## Engineers Comments Regarding Surface Water Drainage

| <b>Application Reference:</b>   | <b>LU/193/25/PL</b>                                                                                                                                                                        | <b>Reviewer Reference:</b> | ADC/EXT2/D2134/86 |
| <b>Site Name:</b>               | Court Wick Park Courtwick Lane Littlehampton BN17 7PD                                                                                                                                      |                            |                   |
| <b>Application Description:</b> | Proposed residential development for 4 houses and associated landscaping. This application may affect the setting of a Listed Building and is in CIL Zone 2 (CIL liable as new dwellings). |                            |                   |

Outfall Manhole PLOTS 1&2 SOAKAWAY : Infiltration Tank

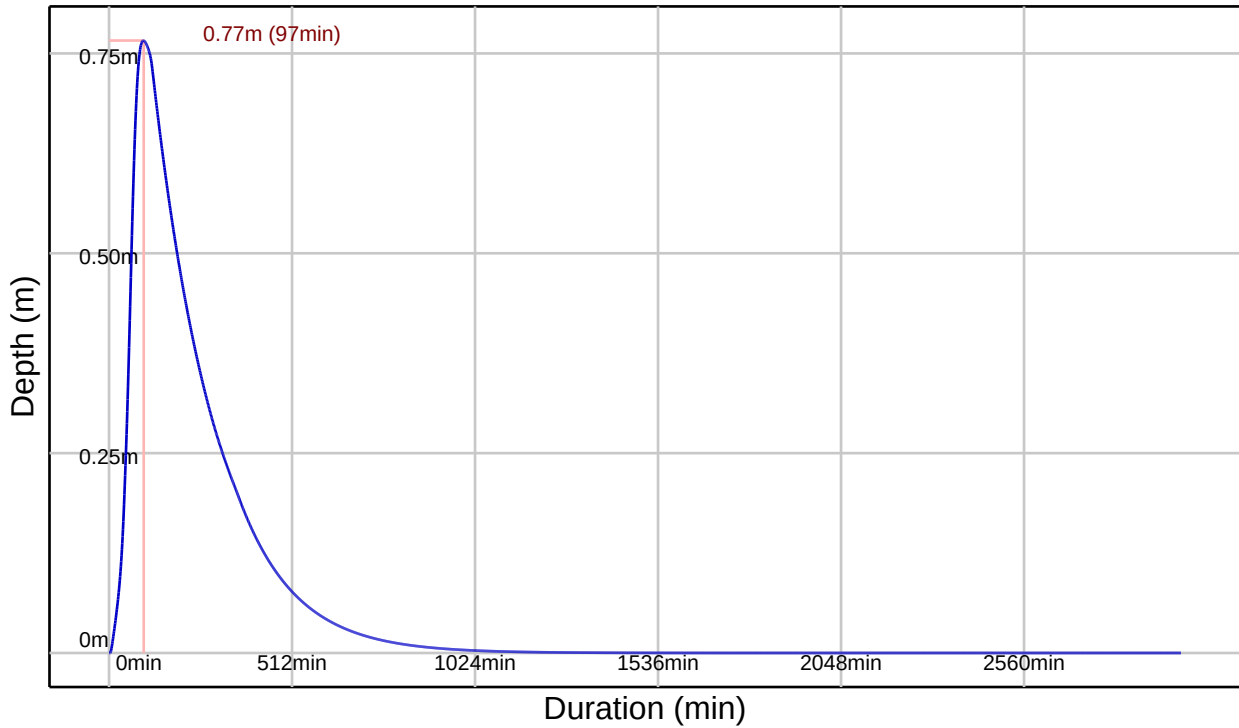
- 0.6. 3 No infiltration test pits have been undertaken in compliance with BRE365 The results advised indicate significant differences across the site, however the designer has not suitably justified why the worst case rates have not been used for all soakaway locations.

- 0.7. In addition the design has not qualified the safety factor (f) consequence of failure. A safety factor of 2 currently specified on the hydraulic calculations is not in accordance with CIRIA.

- 0.9. The second application now includes updated soakaway calculations for the 100yr return period, however these cannot be accepted without the above comments being addressed.

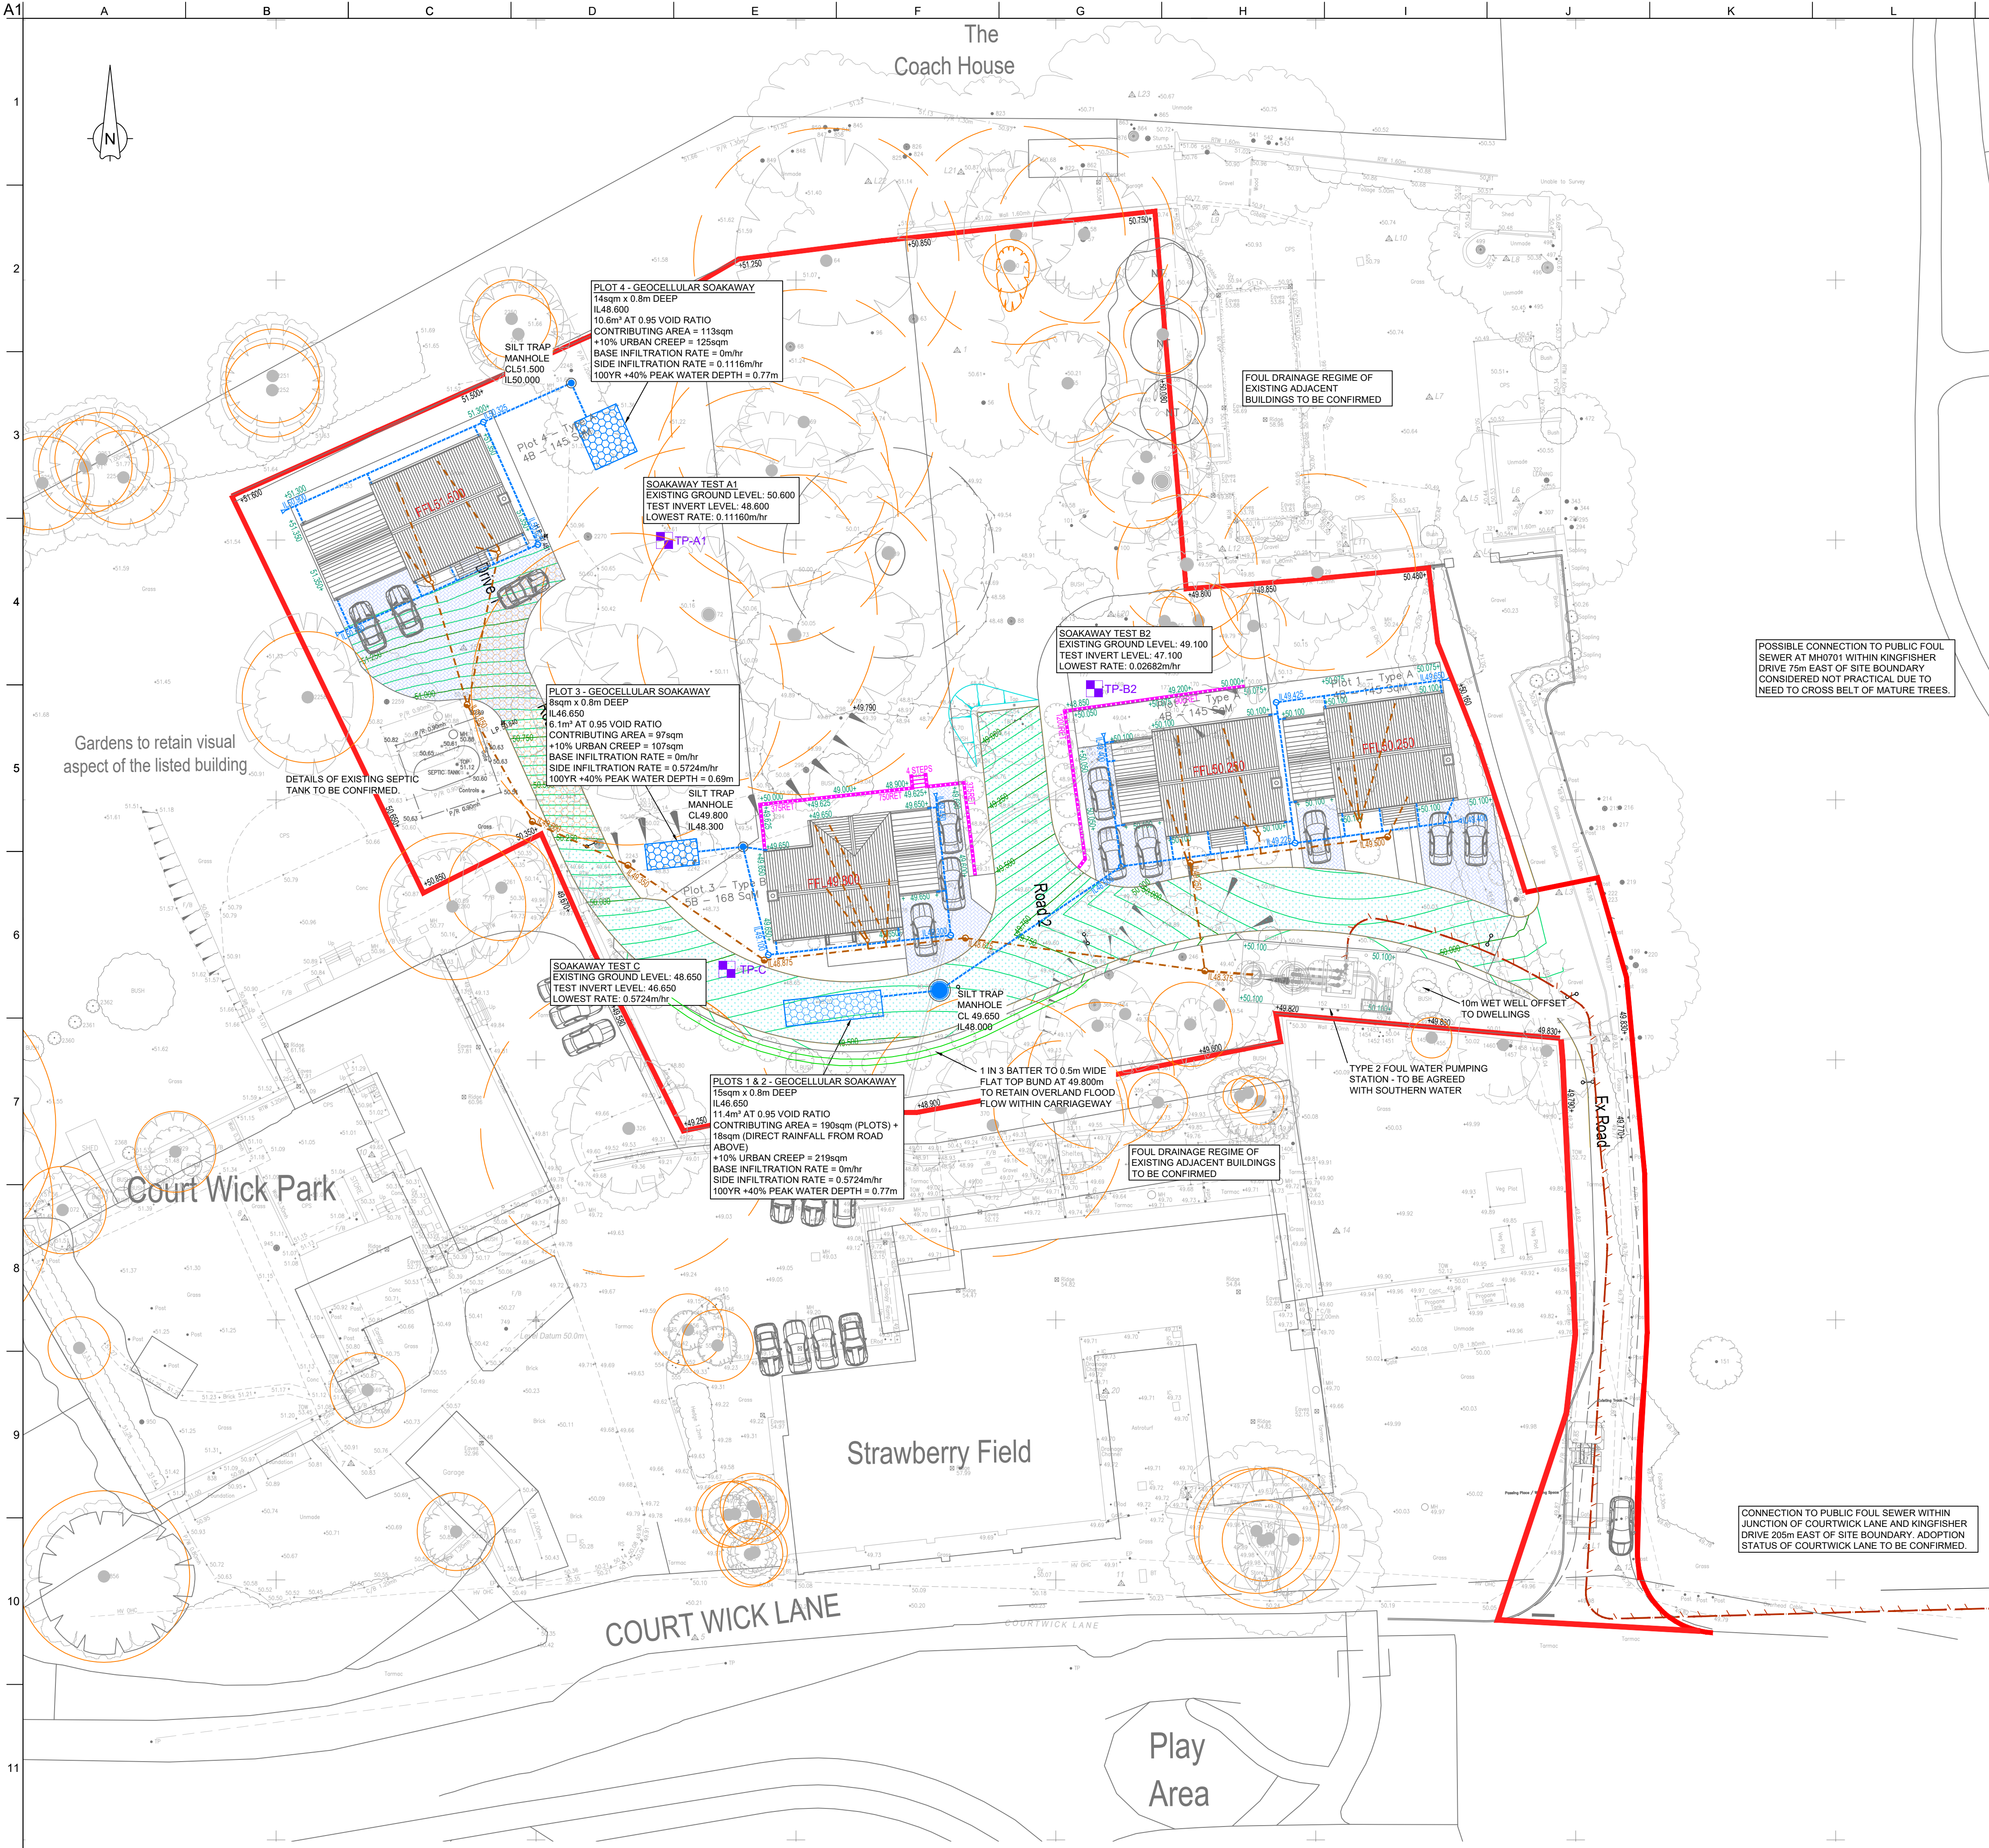
- 0.8. The use of permeable pavements is highlighted on the drainage GA key, however is not shown on the plan. The extent, specification and calculations must be provided.

- 3.1. The drainage design does not comply where the design is for a 10yr return period. This must cater for the 100yr return period, plus climate change and urban creep factors. It must also demonstrate the 50% half drain down time lies within 24hrs for the 30yr event.

7.1. There is the potential for conflict between proposed trees and drainage infrastructure on the site. As landscaping is to be determined by this application it is expected that these conflicts are resolved.
